Awel y Môr Offshore Wind Farm

Comments on Submissions Received at Deadline 3a

Date: 30 January 2023

Document Reference: 4.4

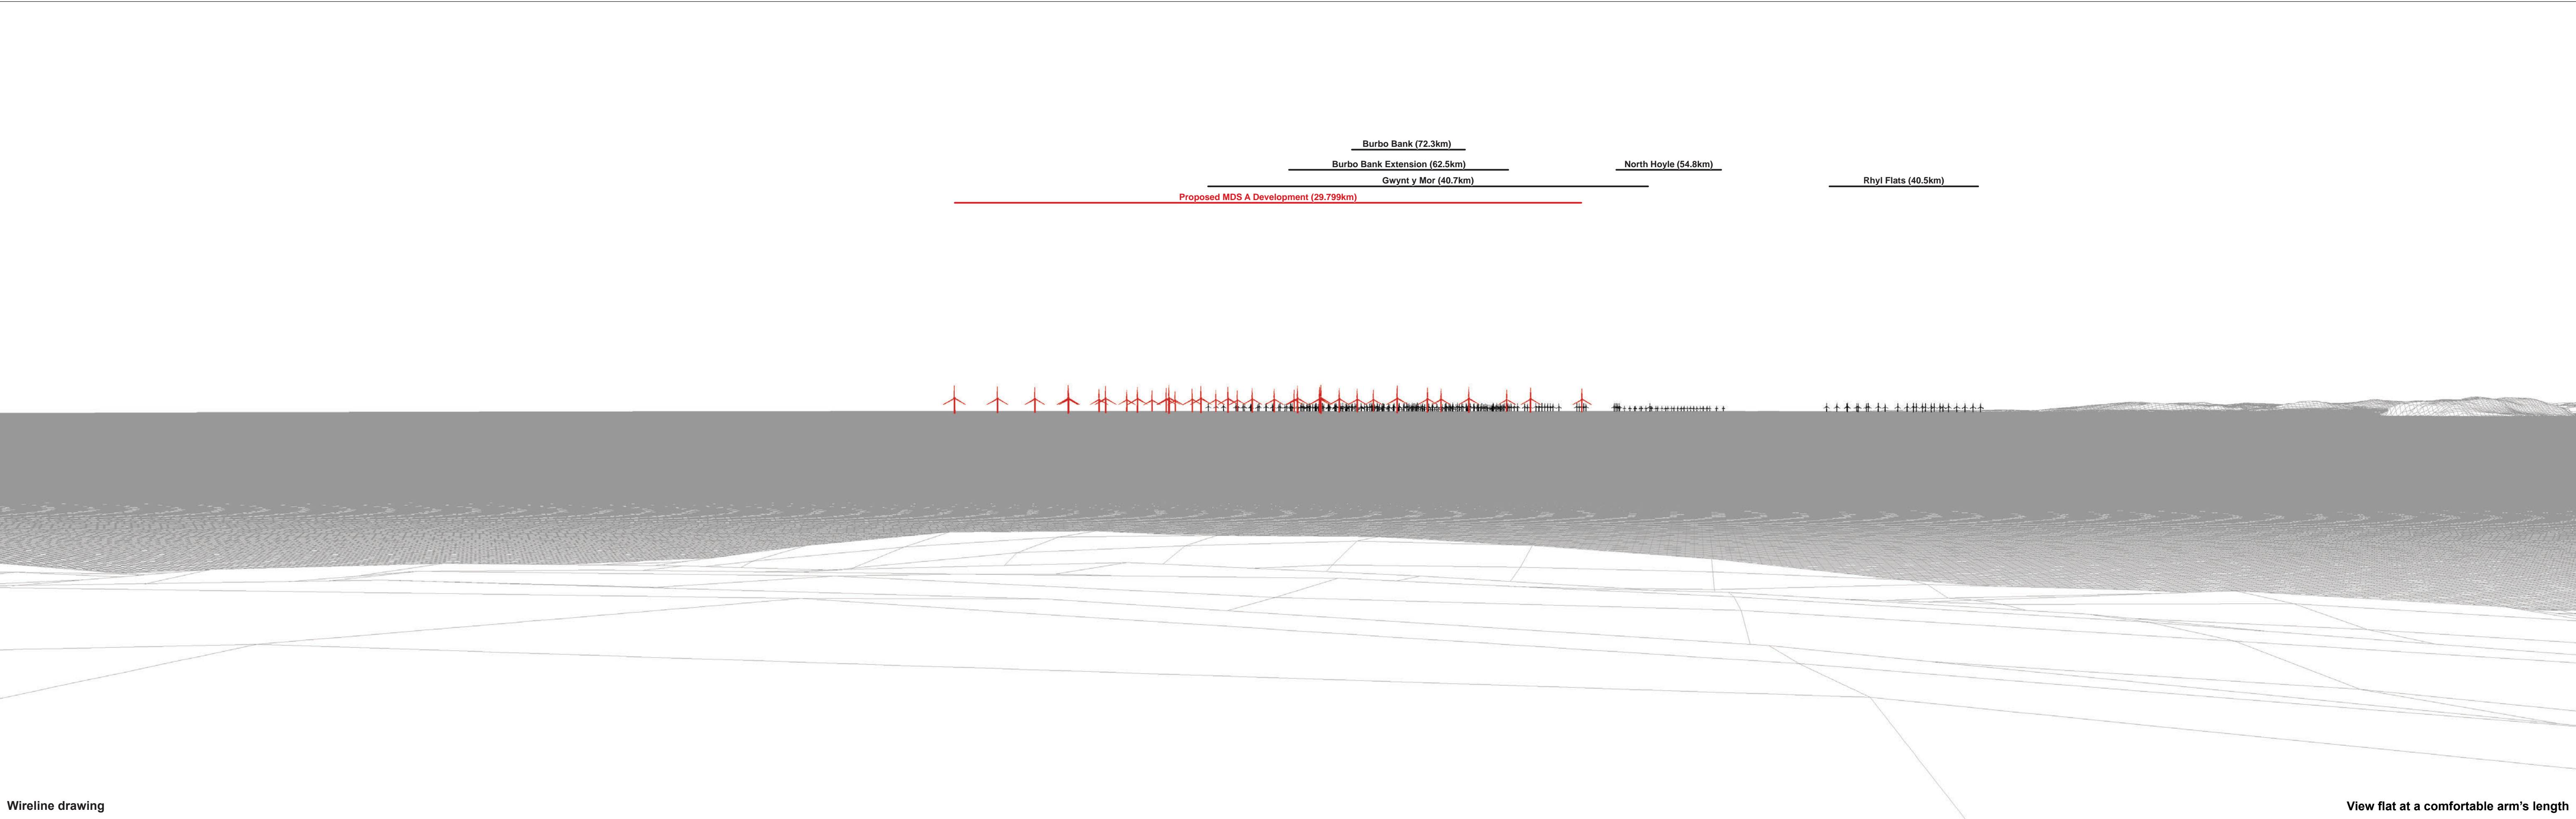
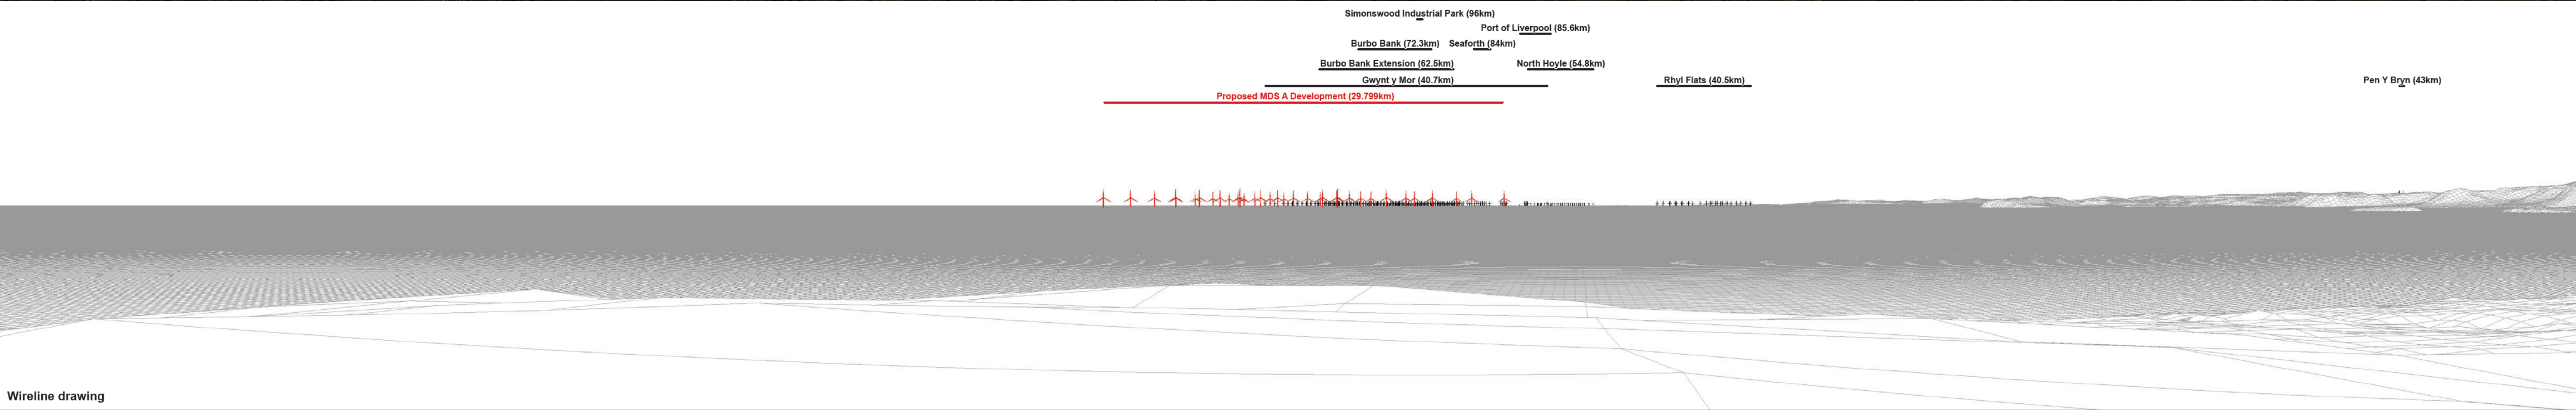
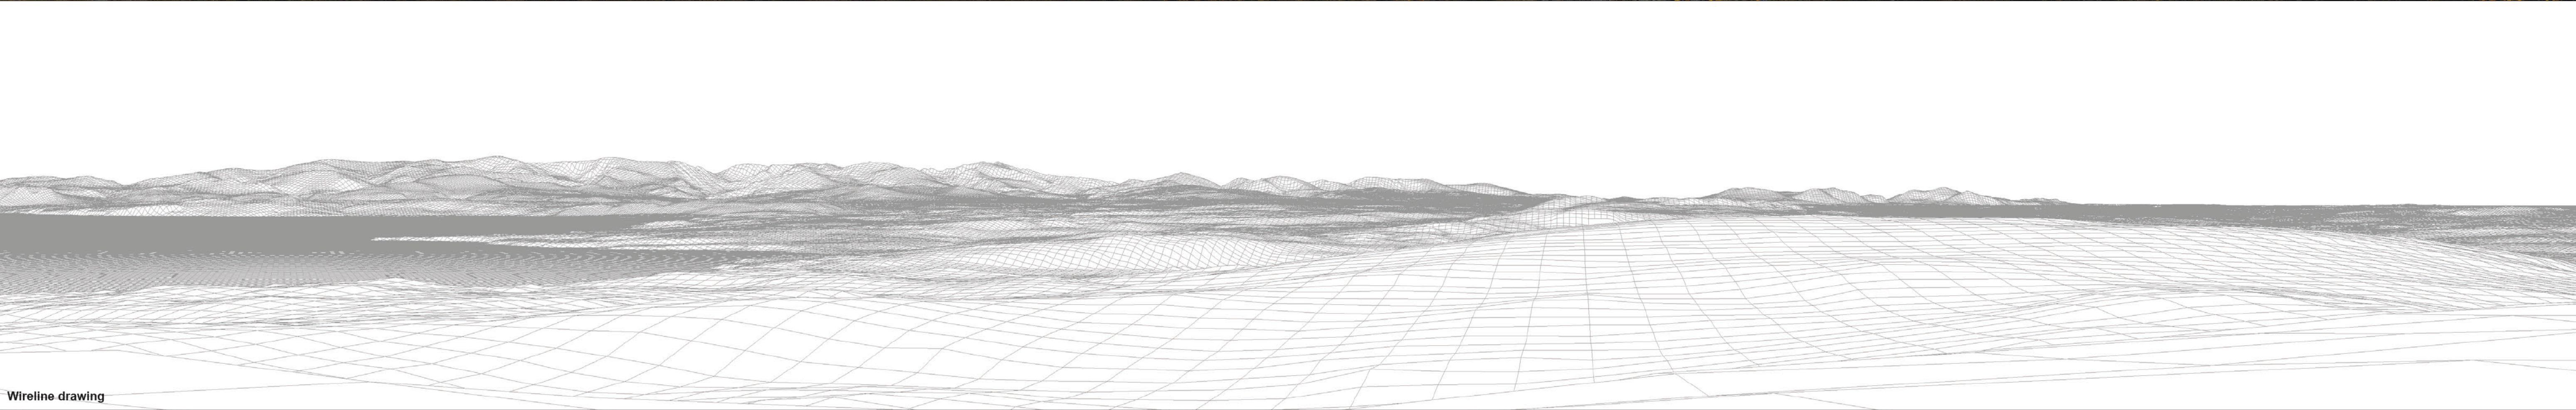
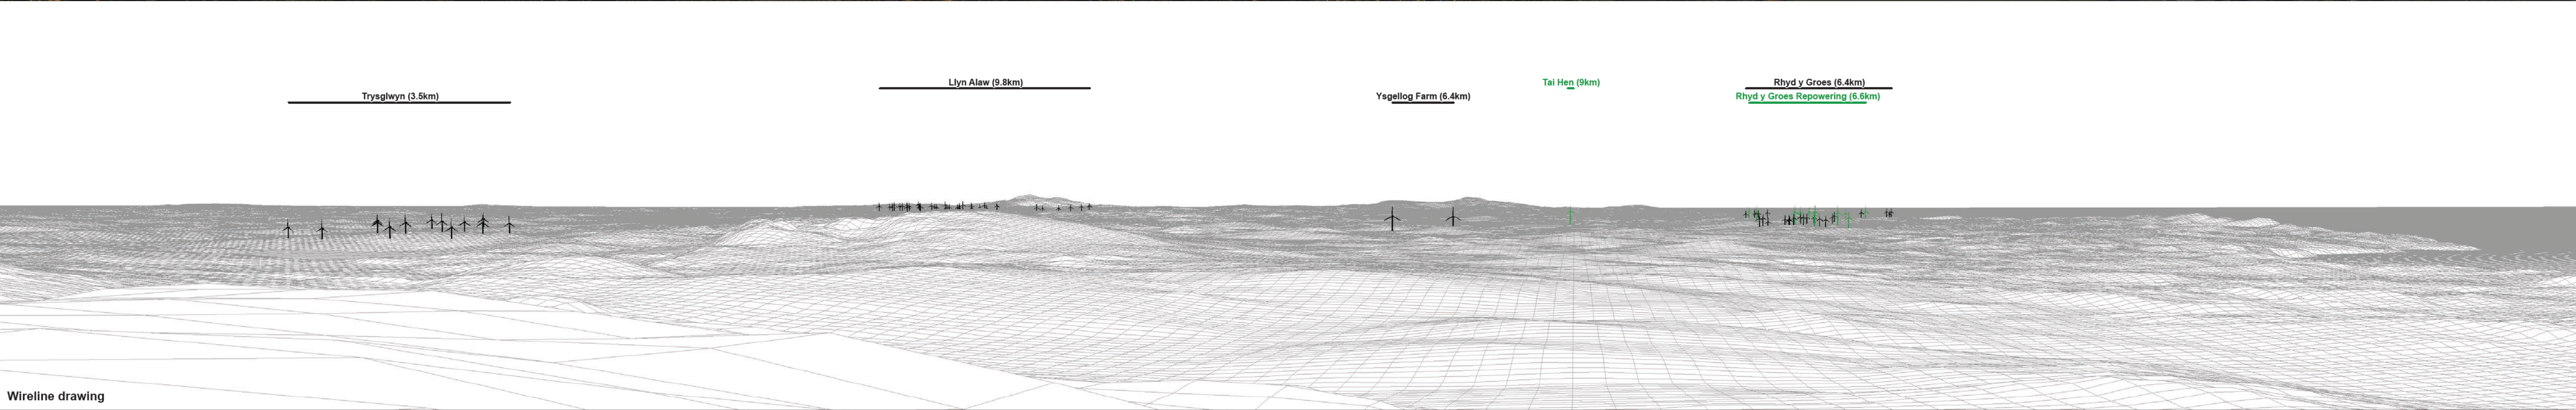
REP3a-021-2.5	<p>- Assessment of Viewpoints</p> <p>In relation to viewpoints (VP) 1 (Porth Llechog/Bull Bay) [APP-230], VP2 (Trwyn y Balog/ Point Lynas) [APP-231] and VP3 (Mynydd Eilian) [APP-232], we consider that the effects at these viewpoints have been underestimated in the SLVIA. We consider the effects to be of low-medium magnitude, and that this level of magnitude combined with high sensitivity should lead to an assessment of moderate adverse effects, which we consider significant. We consider the threshold for significance has been reached for VPs 1, 2 and 3.</p>	<p>As detailed in the Applicant's Written Summary of Oral Submissions (REP3a-004), whilst it is agreed that AyM would be a new component of these views, it is not considered that the effects would be of such magnitude as to make them significant.</p> <p>The SLVIA considers the effects on viewpoints 1, 2 and 3 in table 6 of the SLVIA (AS-027). The high sensitivity of the receptors is acknowledged therein with the assessments also considering the extent of the wide open views affected, the location of AyM relative to the wide open seas and the degree of existing development that effects the views, which is acknowledged does not include offshore wind farms.</p>

REP3a-021-2.6	<p>From these viewpoints, highly sensitive receptors (e.g., walkers on the coastal path) are focused on the coastal landscape and sea views. Although there are large-scale sea views, the scale and nature of the development would make it very noticeable and focus attention upon it. Sea views and the coastline are the key focus of views in the predominantly coastal AONB and sea views are currently untrammelled by development or any other significant human activity, apart from the occasional ship. This part of the AONB is relatively remote and tranquil. The existing offshore windfarms to the east, including Gwynt y Môr, are extremely hard to discern even in fine weather and built development along the coastline is not similar in nature or scale to the proposed wind farm. The proposal would interfere with the appreciation of the open sea and coastline including views of coastal landforms and the mountains of Eryri (Snowdonia). Windfarms</p>	<p>The Applicant considers that although the turbines would be noticeable in the seascape, the magnitude of change would be low and the effects would not be significant based on professional judgement.</p> <p>Professional judgement on the significance of the effects or otherwise must be applied by viewing the visualisations at the viewpoints where the wide open seas, that would remain a key characteristic of the views, can be properly appreciated The Applicant also considers that the extent of AyM as a minor part of the overall seascape should be considered.</p>

REFERENCE	WRITTEN SUMMARY COMMENT	APPLICANT'S COMMENT
	inland, as seen from Mynydd Eilian, are smaller scale and associated with the inland rural landscape and not sea views and the coastline.	
REP3a-021-2.7	In relation to VP36 [APP-265], we consider that the effects at this viewpoint have also been underestimated and are likely to be significant adverse. The SLVIA describes sensitivity as medium-high and the effects non-significant (moderate). It claims that the experience is already modified by existing wind farms and pylons. We disagree and consider that, at this viewpoint, existing onshore wind farms and pylons are hard to discern, and that Gwynt y Môr and other offshore wind farms are only visible at a distance, appearing small scale and not prominent in views. Existing housing and other built development in the view is of a very different scale and nature to the proposed wind farm, which would contrast strongly with it.	<p>As detailed in Table 9 of the SLVIA (AS-027) and noted in the Applicant's Written Summary of Oral Submissions (REP3a-004), the Applicant notes that VP36: Tal-y-Fan already includes existing offshore wind farms and substantial, coastal, urban development in the view and these were very apparent during field work, which was undertaken in very good weather conditions. The photographs do not accurately capture the degree of visibility of the existing offshore wind farms apparent at the time. It is such good visibility or excellent visibility conditions that were assumed when assessing the significance of the effects of AyM.</p> <p>This has been one factor that has resulted in the assessment of magnitude of change as medium-low and the effect being assessed as Moderate (Not-significant).</p> <p>The Applicant notes that as shown in SLVIA Viewpoint 36 (APP-265) Rhyl Flats OWF is closer to the viewpoint than AyM and although smaller in scale is likely to be more frequently visible from this location.</p>
